Recommendation Report for Planning Permission

REF NO: LU/220/18/PL

LOCATION: 70 High Street
Littlehampton
BN17 5DY

PROPOSAL: Alterations & change of use to existing bank (A2 Financial & Professional Services) to mixed use to retail (A1 Shops), office (B1 Business), 3 No. residential dwellings (C3 Dwelling house) & dormer at second floor level (submission following LU/50/17/PL & LU/6/18/PD). This application may affect the setting of a listed building.

EAST + NORTH ELEVATIONS - PROPOSED
70 HIGH STREET, LITTLEHAMPTON, SUSSEX.
GRAHAM NICOLLS LTD.

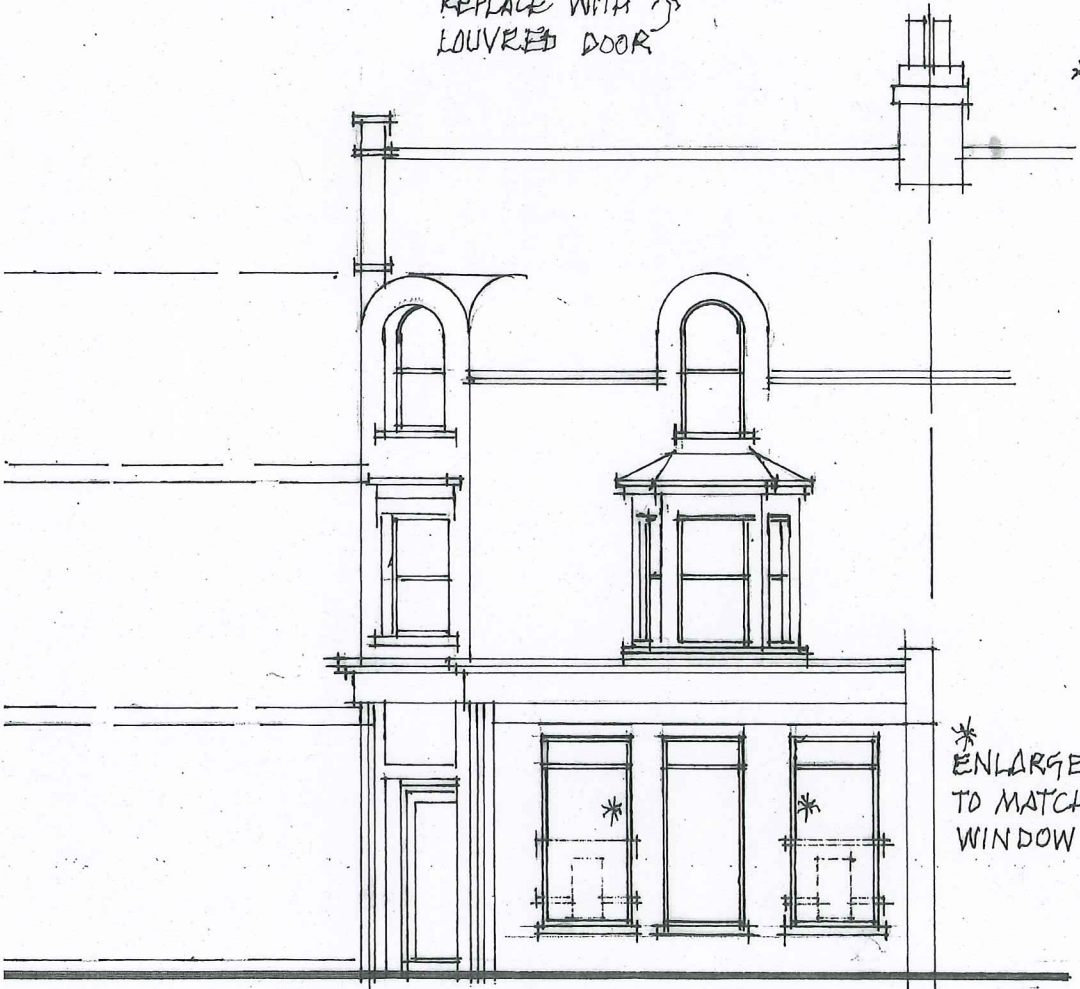
The north and east elevations are the most significant from the perspective of the buildings significance. The concept of lowering the windows is understood and accepted as a means of enabling the continued use of this element of the ground floor as a retail unit. However, the means of lowering the windows may be problematic, and should be designed so that they read exactly as the other ones already on the ground floor. Details of the windows and their surrounds will need to be provided to the council by way of condition, so that there is the opportunity to ensure that the works match the existing.

Reason: For the avoidance of doubt and in the interests of amenity and the environment in accordance with policy DDM1 of the Arun Local Plan.
- 3 No external ground floor alterations to the North elevation of the shop front shall be undertaken until a schedule of materials and finishes to be used for the shop front have been submitted to and approved by the Local Planning Authority and the materials so approved shall be used in the construction of the shop front windows.

GROUND + FIRST FLOOR - PROPOSED

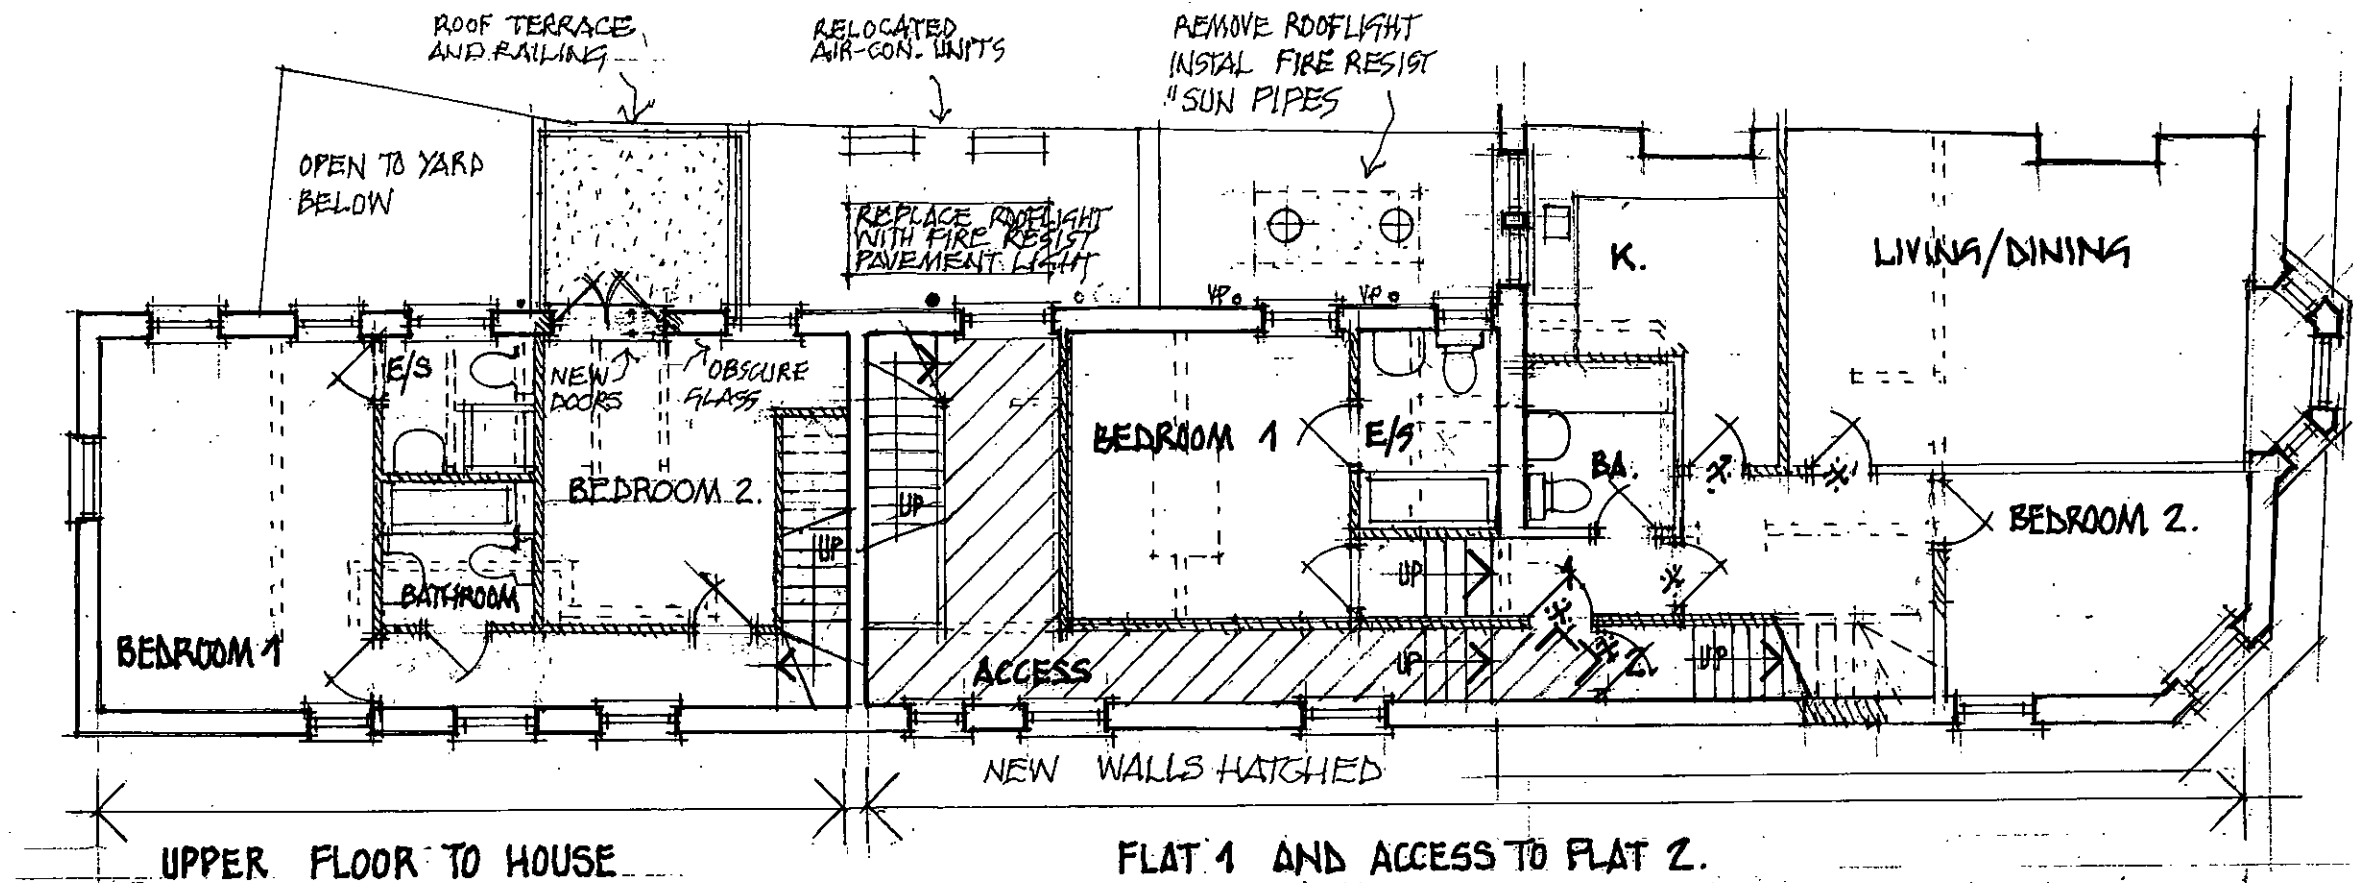
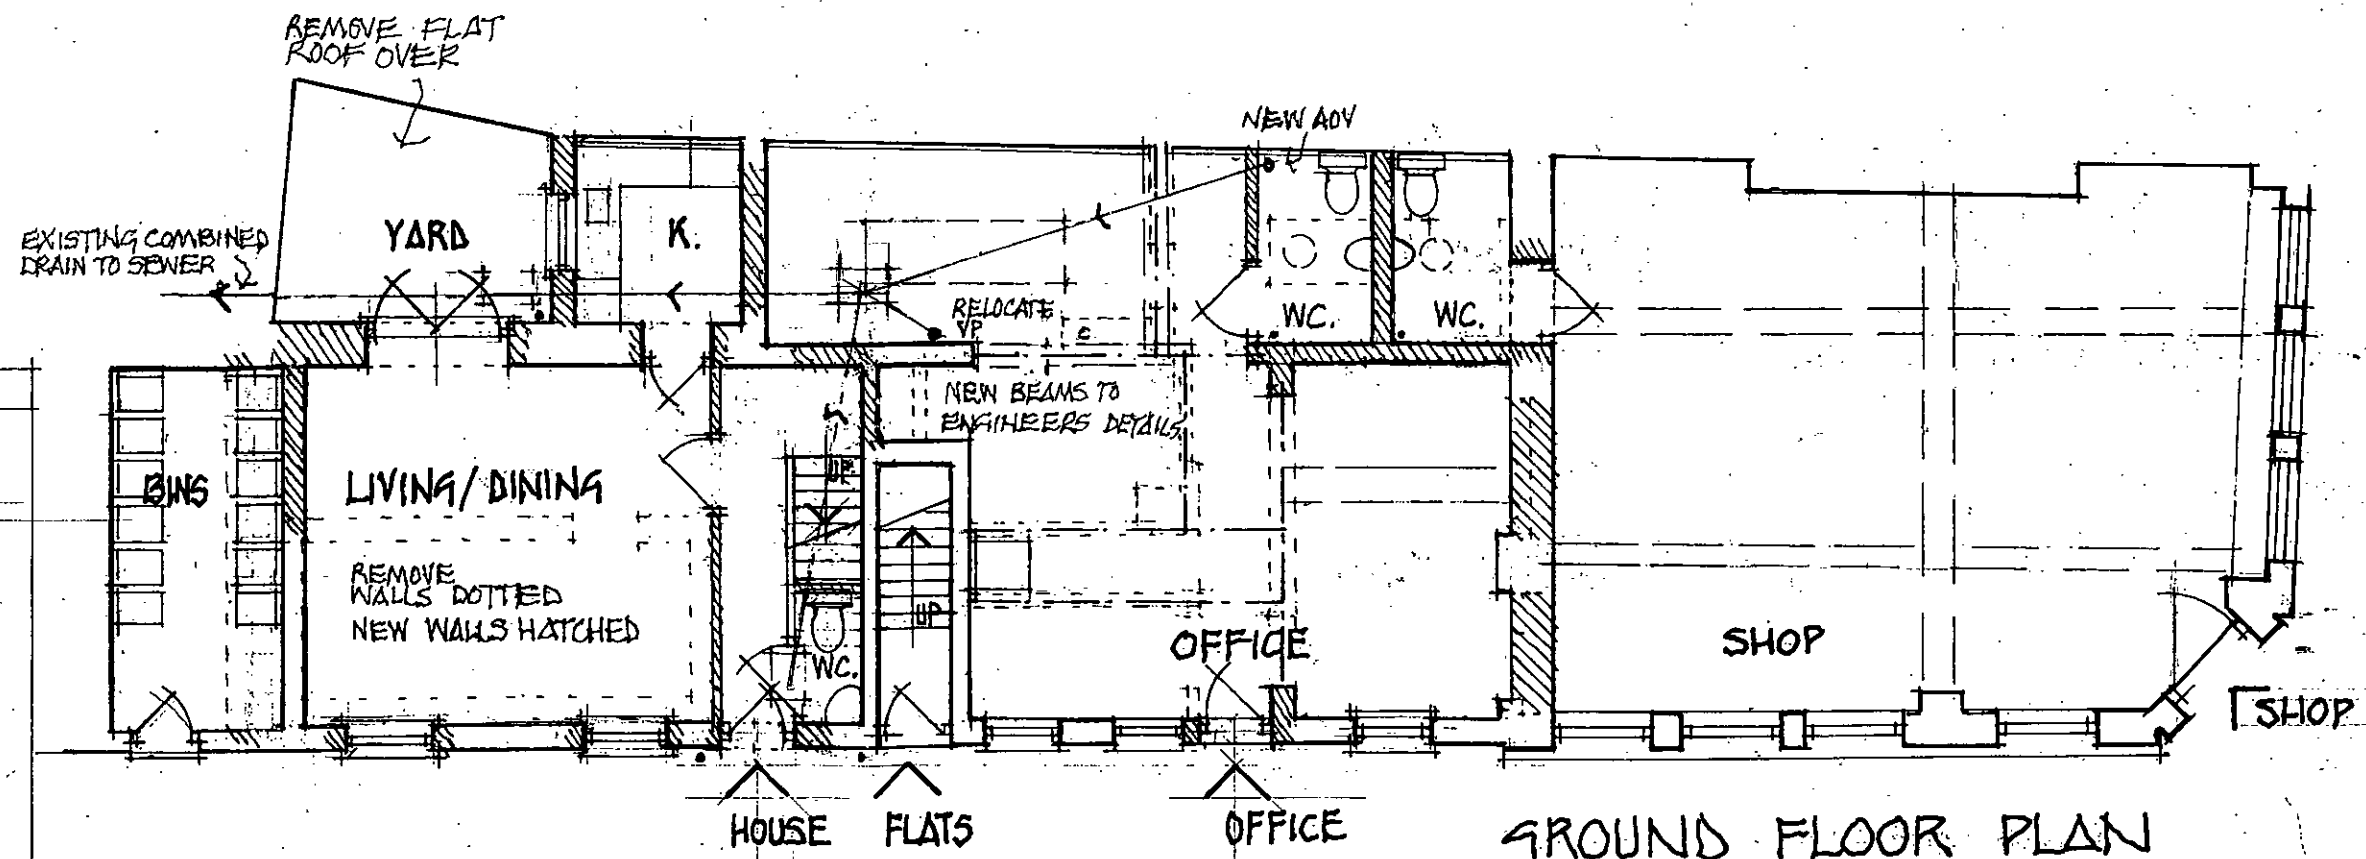
Environment Agency - No Objection. It is noted that the flood risk information contained in the Design Statement is not sufficient for a Flood Risk Assessment (FRA), and that a suitable FRA should have been provided in accordance with paragraph 163 of the National Planning Policy Framework (NPPF). However, considering this is a change of use, and the majority of the residential dwellings are proposed on the first floor and above so that no sleeping accommodation will be located on the ground floor with safe refuge available at first floor (in accordance with drawing no. 080418/TP01C), we see no reason to

SOUTH + WEST ELEVATIONS - PROPOSED

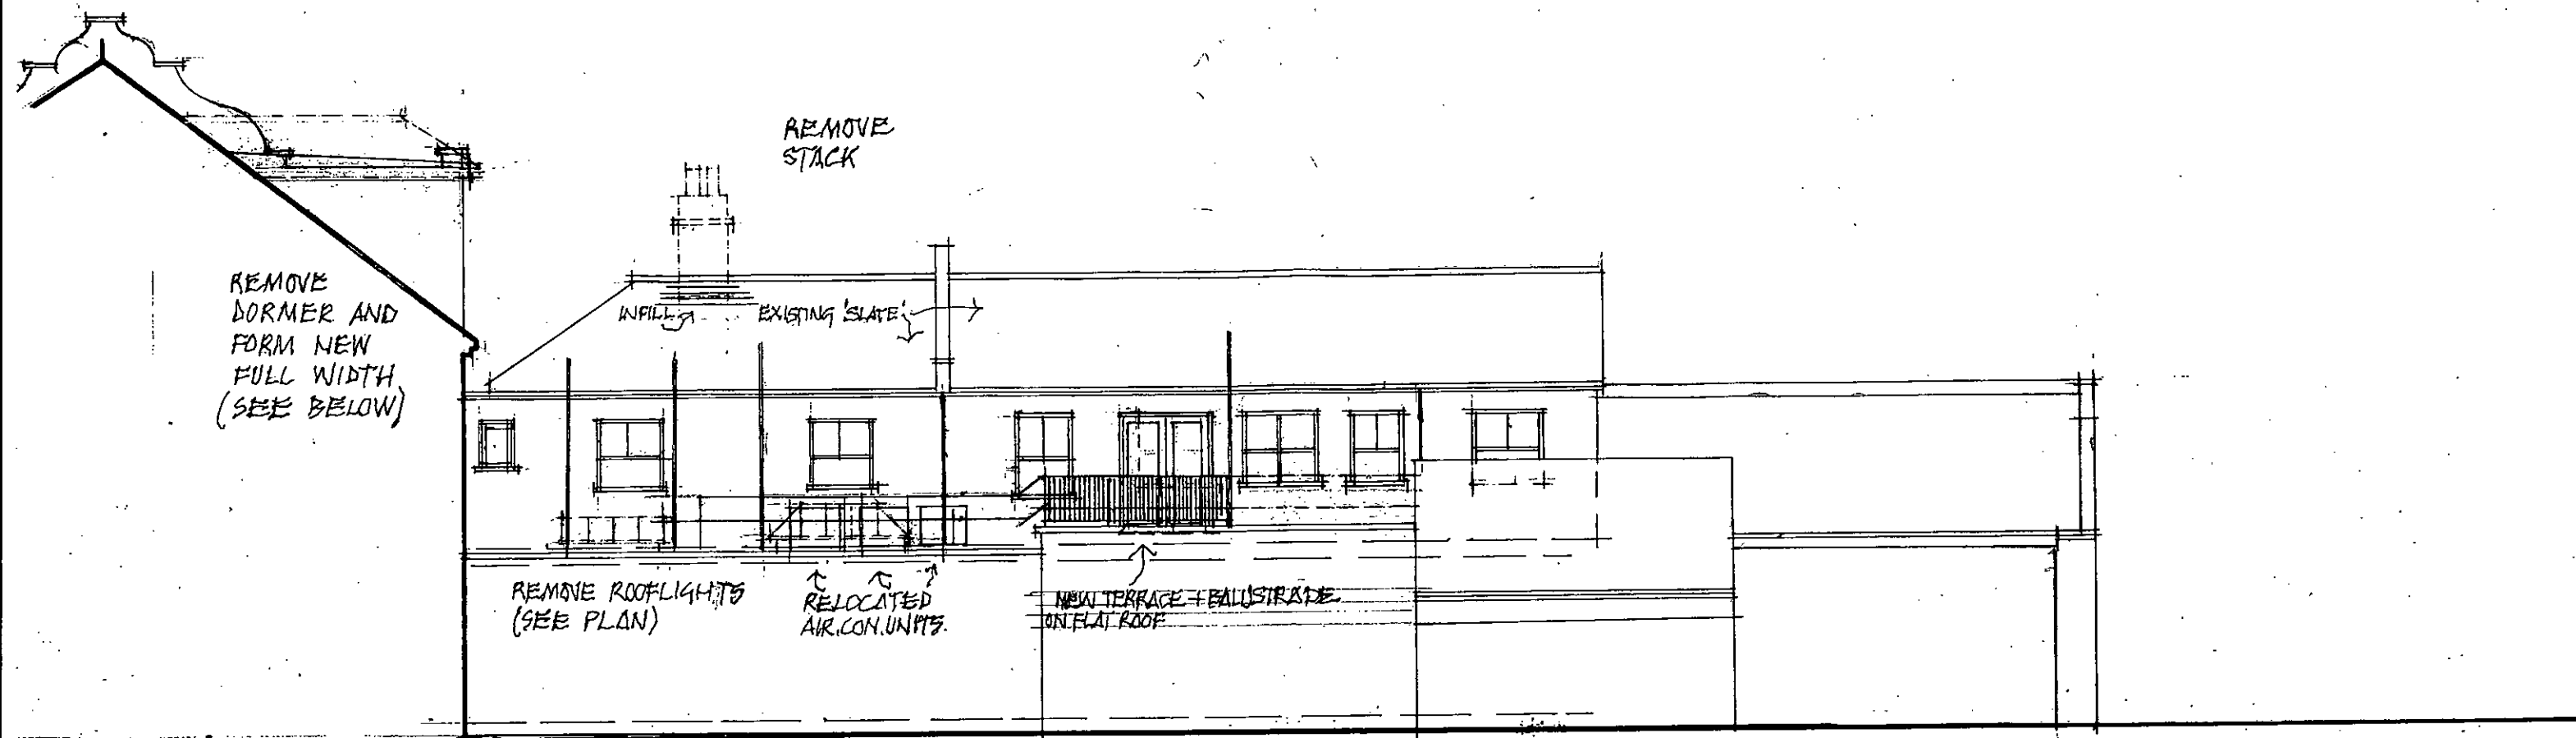
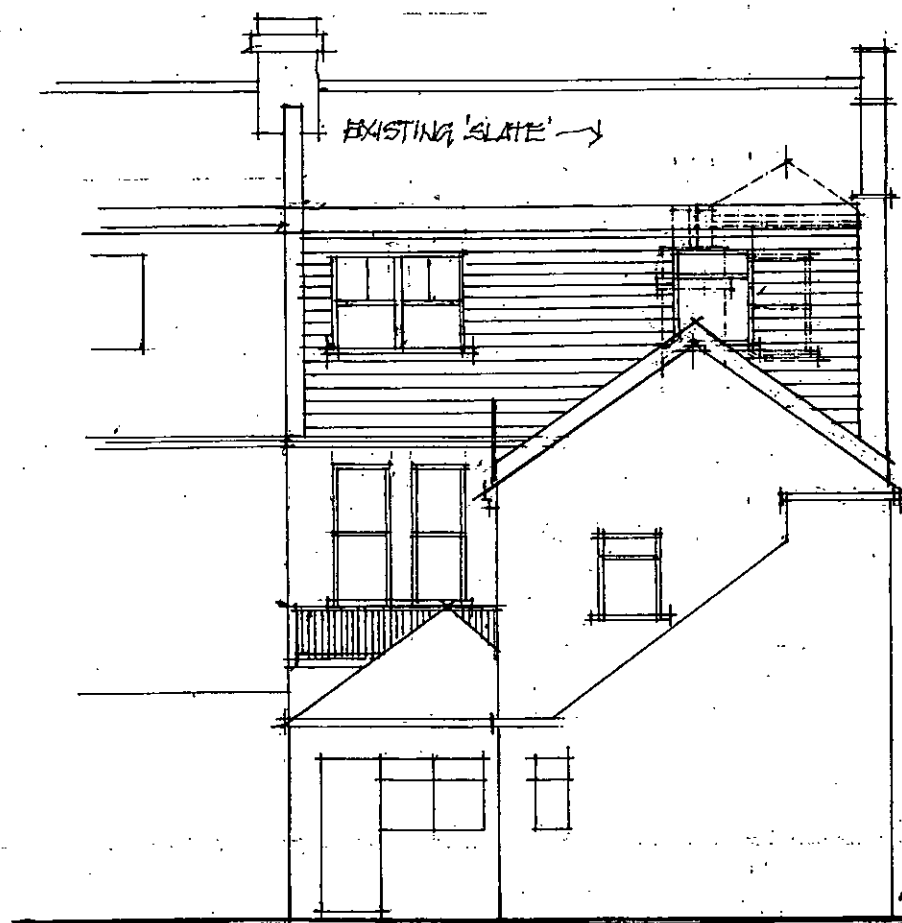
The rear dormer is large in scale, but is not necessarily significantly visible from the public realm. However, it is considered to be bulky in nature, and it is thought that a modestly scaled dormer of traditional proportions would be better placed in this location.

The proposed dormer window will be located on the southern elevation of the property at third floor level. A dormer window was previously approved on the rear elevation under LU/50/17/PL, but this proposed dormer window is larger and extends across the whole ridge slope. It will be clearly visible within the street scene when viewed from Clifton Road to the south as well as from within Sparks Court. The proposed dormer window will have a limited presence within the street scene when viewed from the east and north by virtue of its design and location.

The new dormer face will be slate hung to match existing roof coverings. By virtue of its design and location it is considered that the proposed dormer window will appear subservient to the host building and well integrated subject to the use of materials which match those of the existing structure. Therefore, the proposed dormer is deemed in accordance with policy DDM 1 and DDM 4 of the Arun Local Plan.
